TO: All Staff  
FROM: Justin Turnbull, County Surveyor   
DATE: April 6, 2022  
SUBJECT: County 2<sup>nd</sup> Survey Review of BL-20-00032 Evergreen

**Please note that while typically a second review will only address whether prior comments have been addressed with the resubmittal, the prior submittal had such significant issues regarding access, that a complete review was not performed.**

**BOUNDARY LINE ADJUSTMENT BL-20-00032**

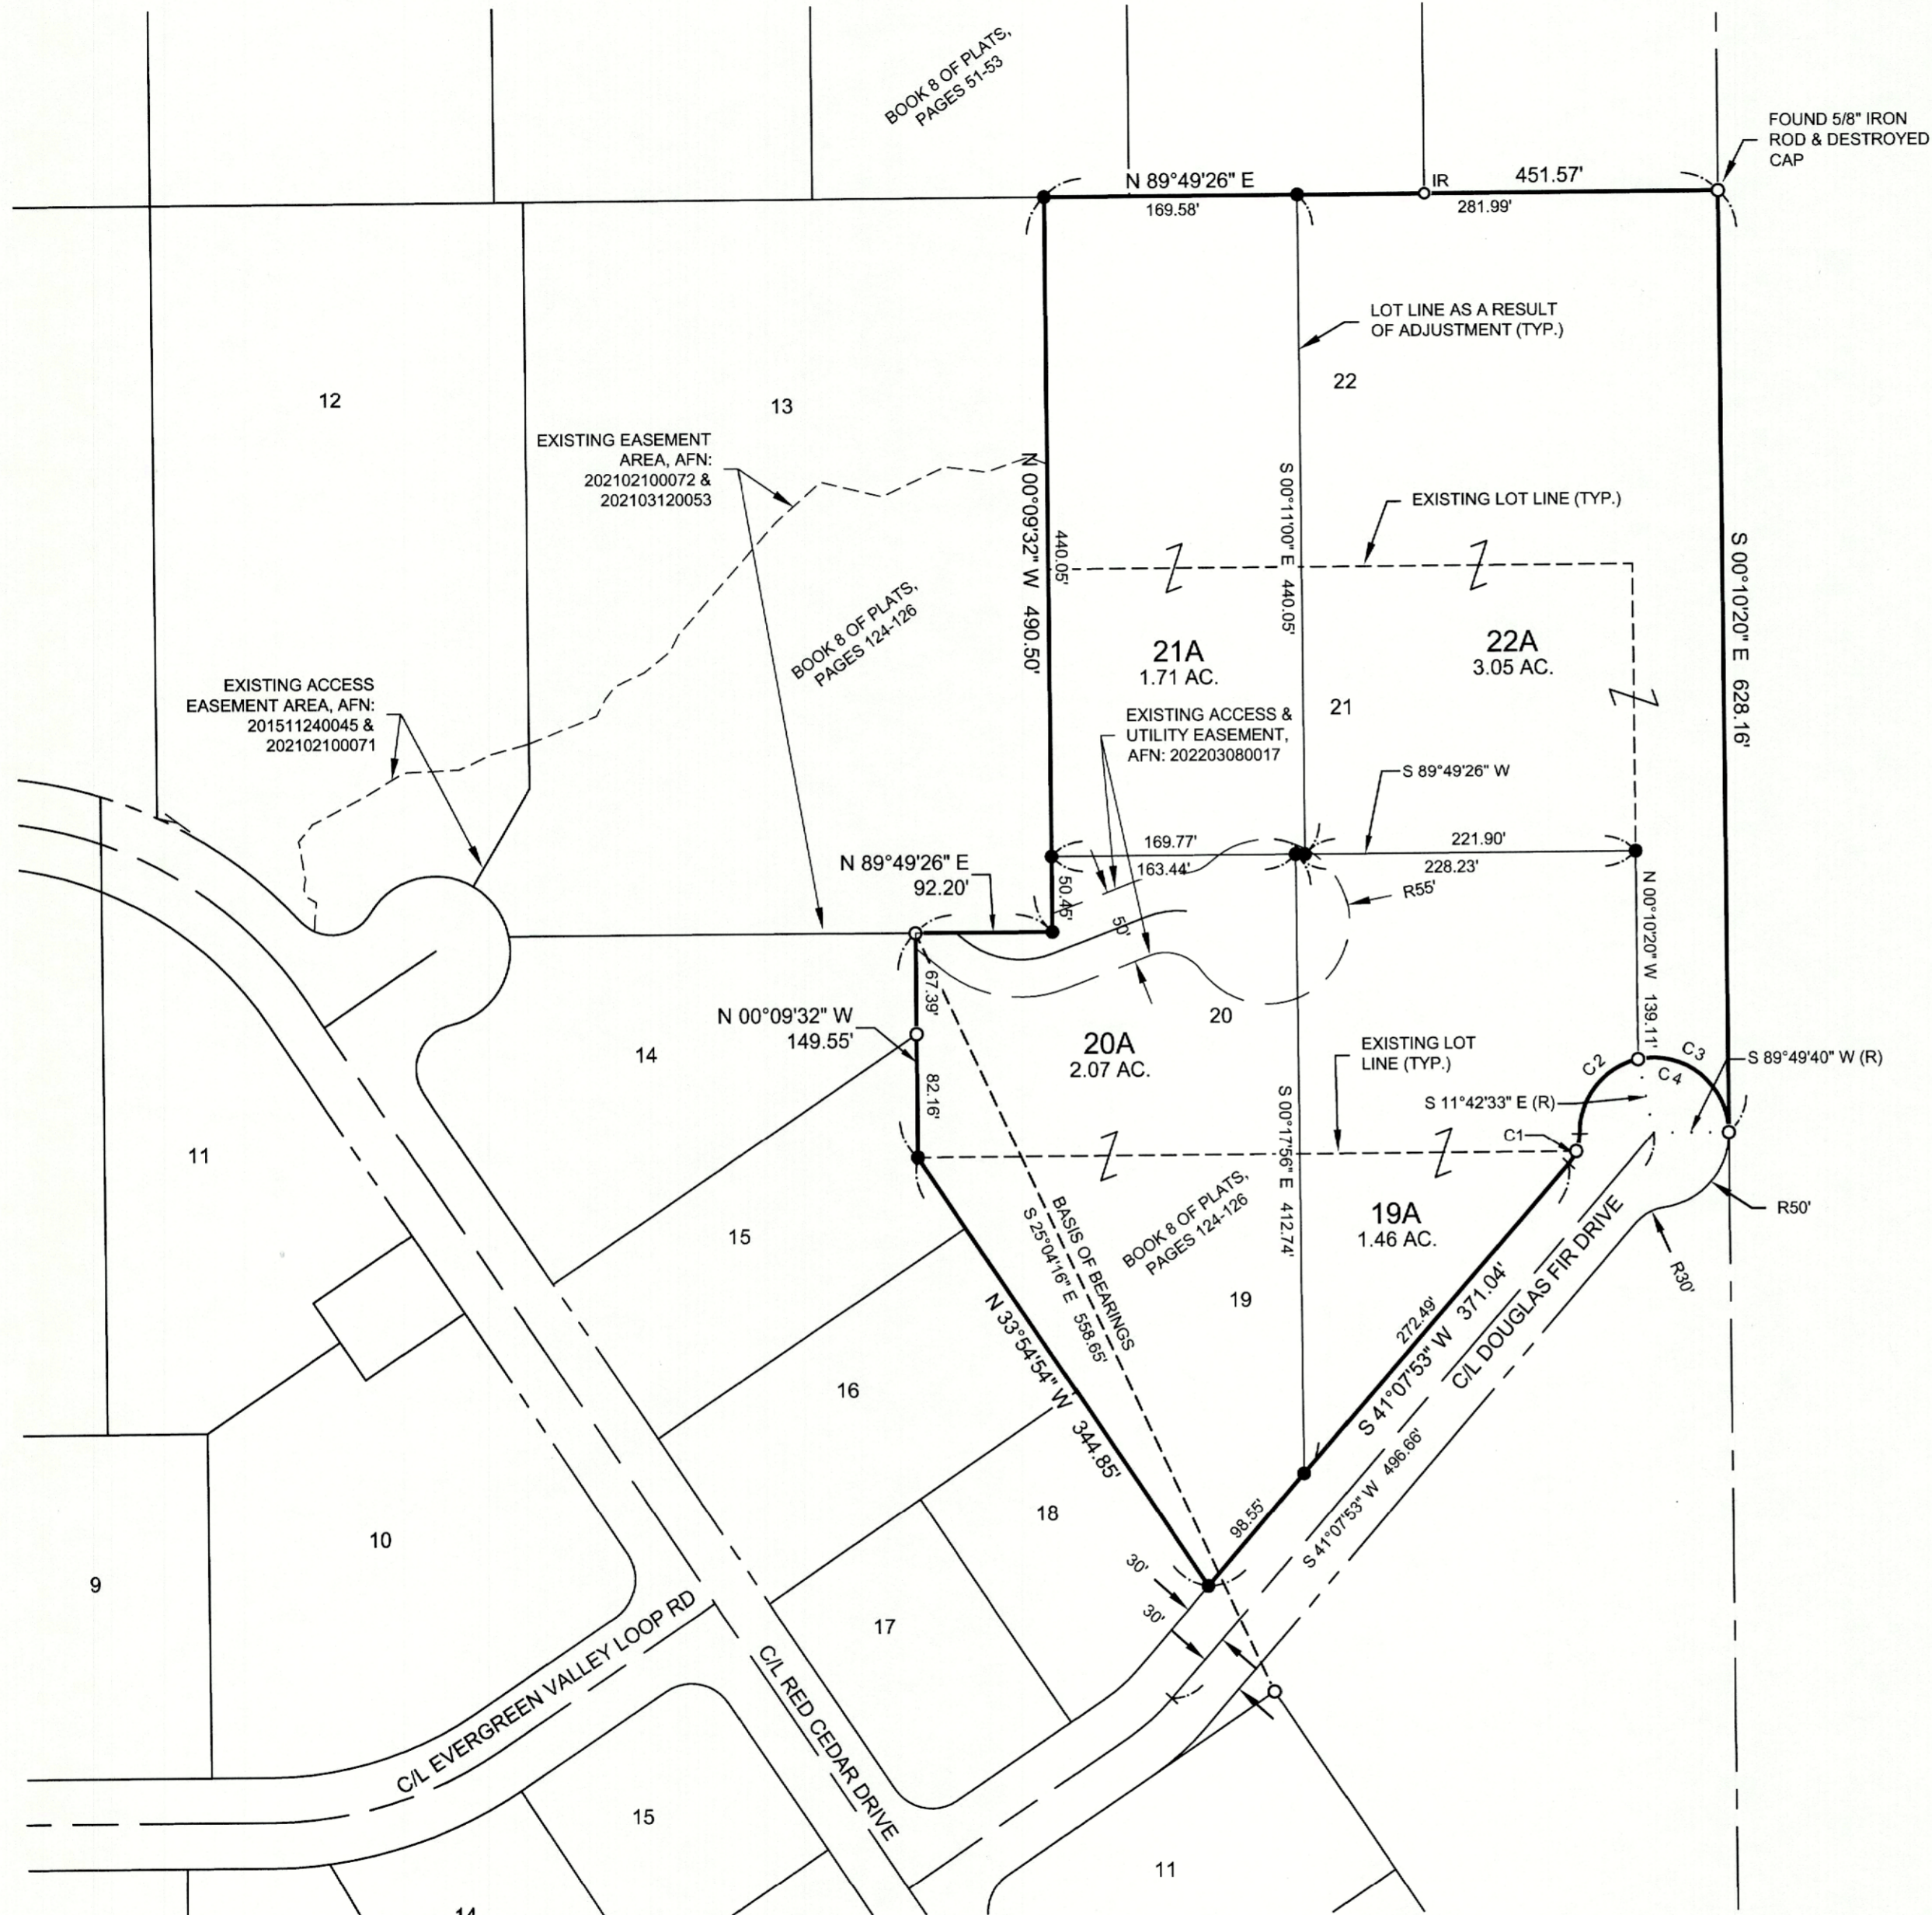
1. There are multiple occurrences of dimension text being obscured by crossing linework.
2. All Roadways must show name, width, underlying ownership (Private/County/State), easement or right of way, and surfacing material.
